REQUEST

Current Zoning: B-1 (CD) (neighborhood business, conditional)
Proposed Zoning: B-1 (CD) SPA (neighborhood business, conditional, site plan amendment)

Approximately 13.211 acres located along the northern side
Albemarle Road between Rocky River Church Road and Blair Road

The petition proposes to amend an existing approved site plan (1998-042C) to permit additional uses including an additional EDEE with accessory drive through and other uses permitted by right and under prescribed conditions in the neighborhood business district.

Rezoning Petition No. 98-42(c)
Development Standards
Woodland/Beaver Farms Site
Revised - February 18, 2020

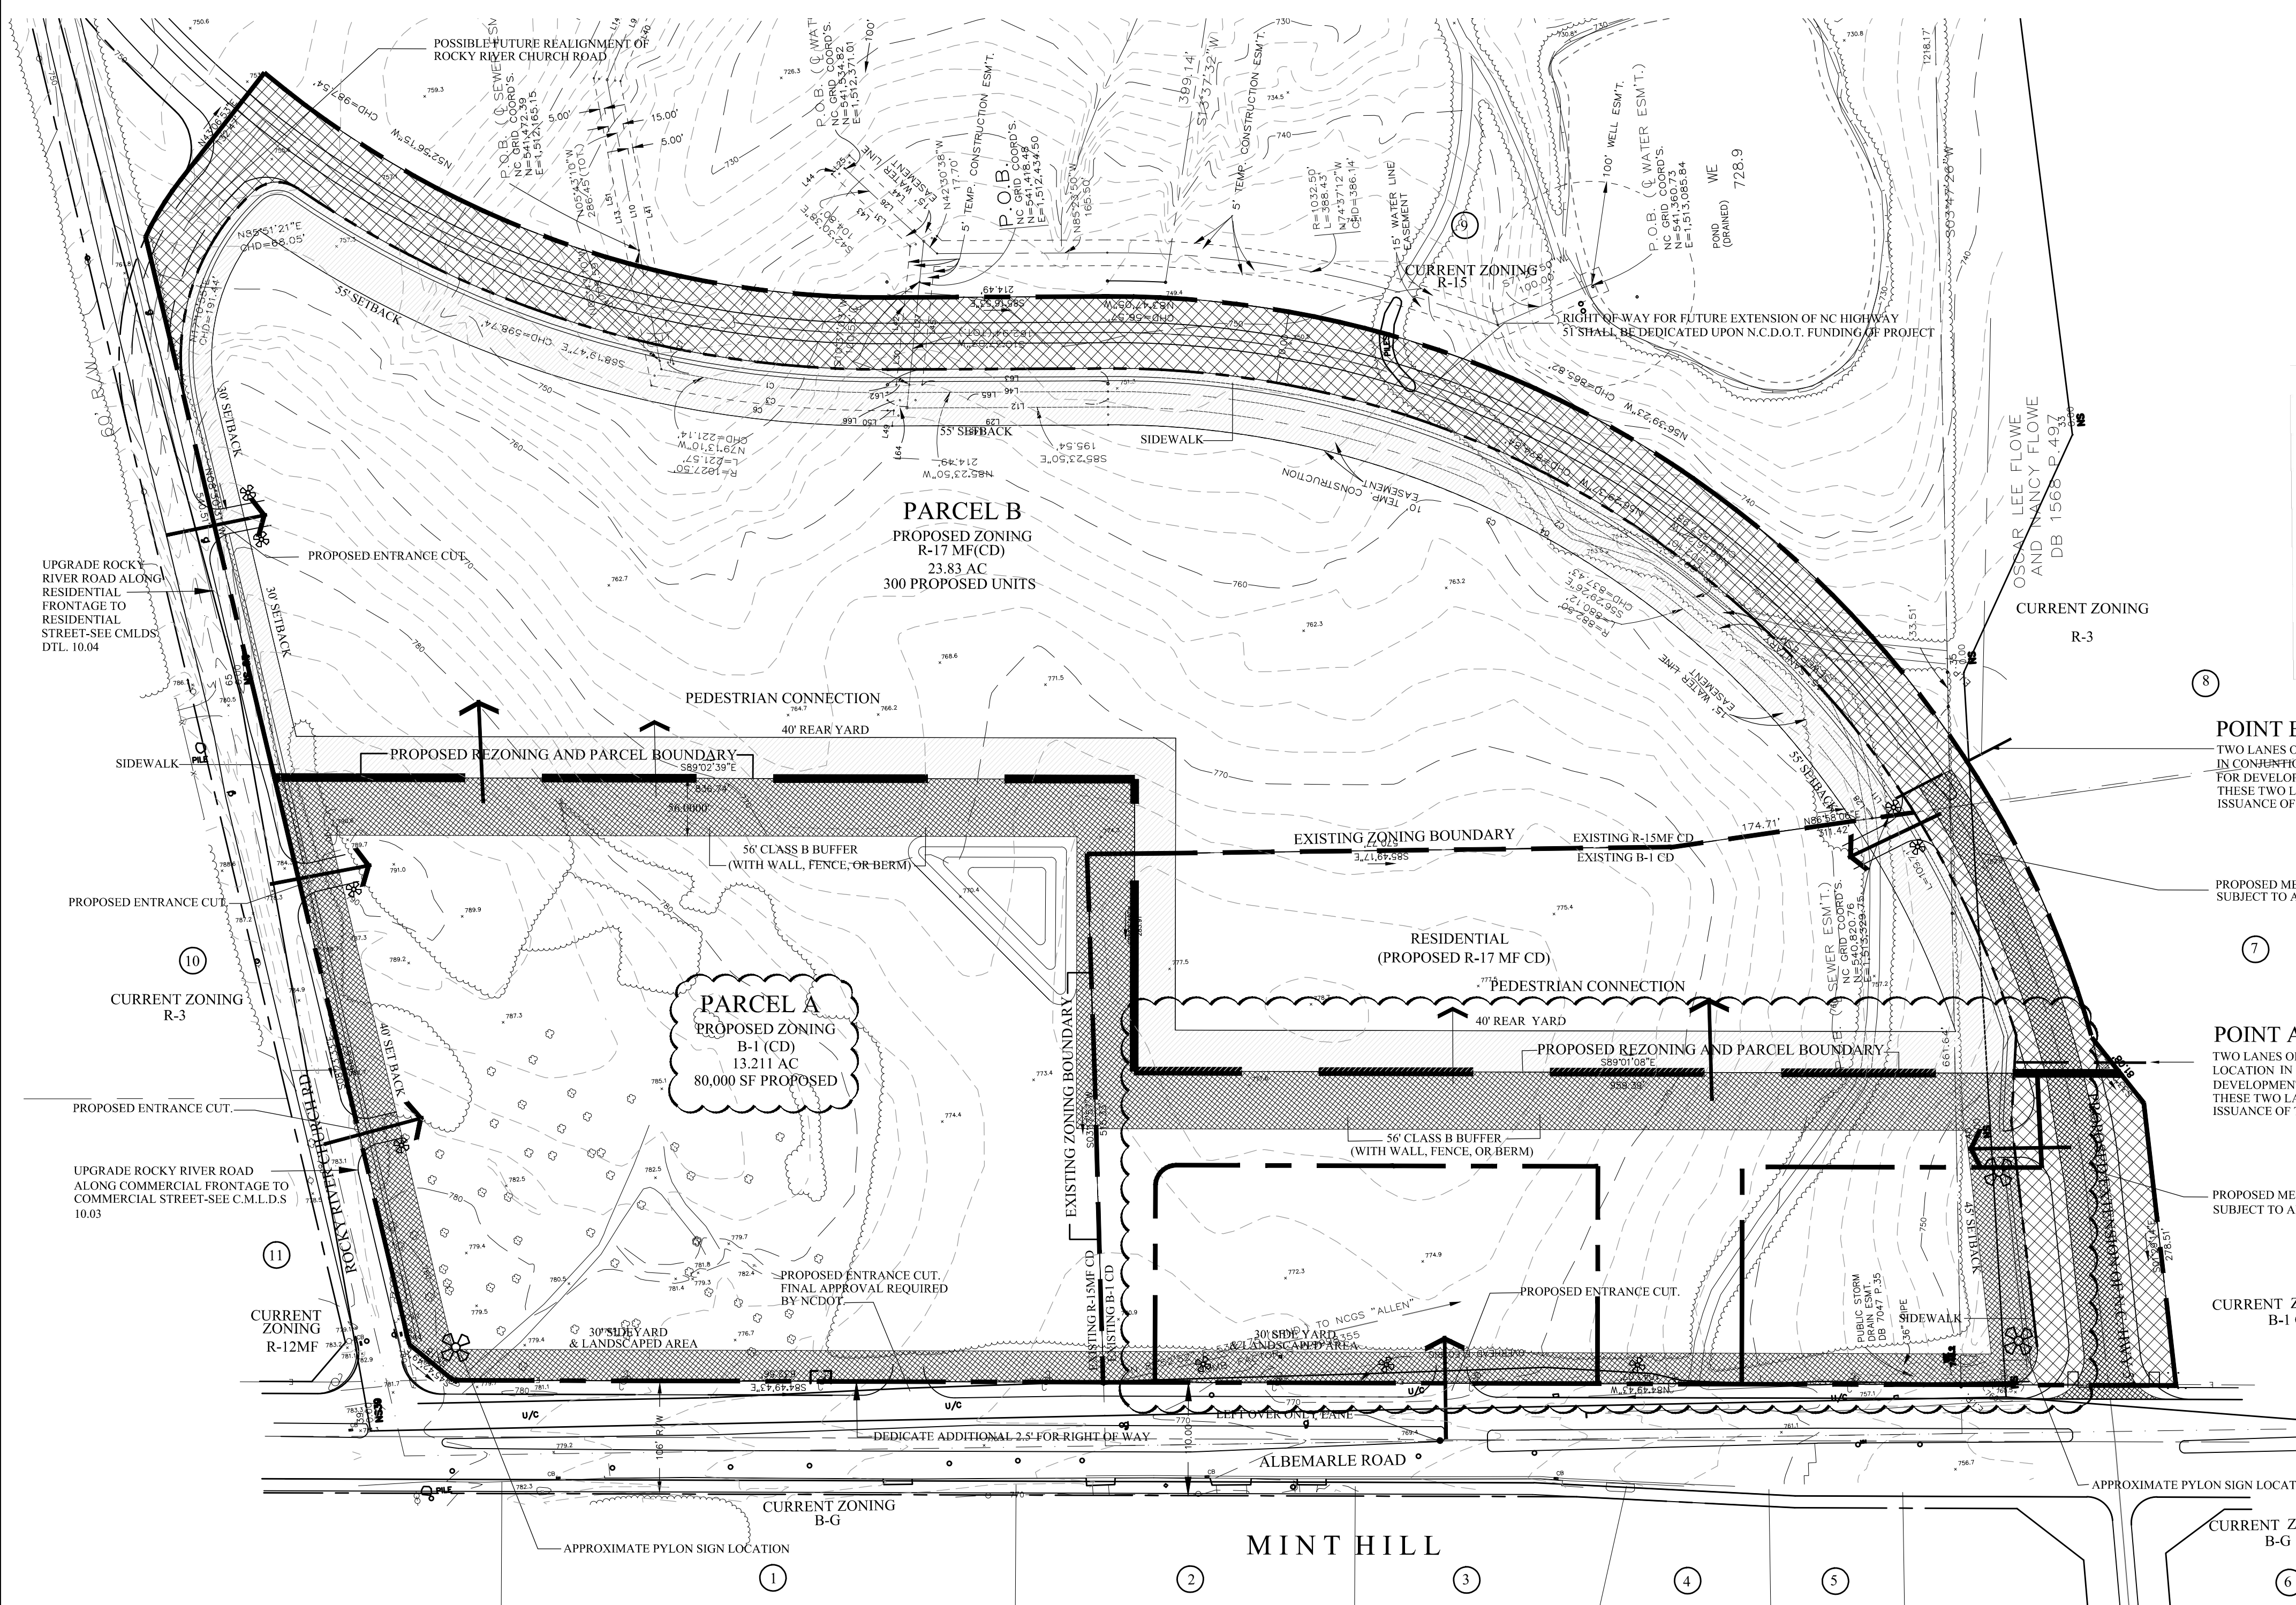
2. ~~Revise conditional notes in section F to include hotels as a use subject to the architectural controls listed for non-residential uses.~~ **ADDRESSED**
 3. ~~Revisit language in conditional note F.1.(c) to more precisely describe where/when a building with an accessory drive-through window or service lanes/windows may present a circulation drive between the building and adjacent streets.~~ **ADDRESSED**
-
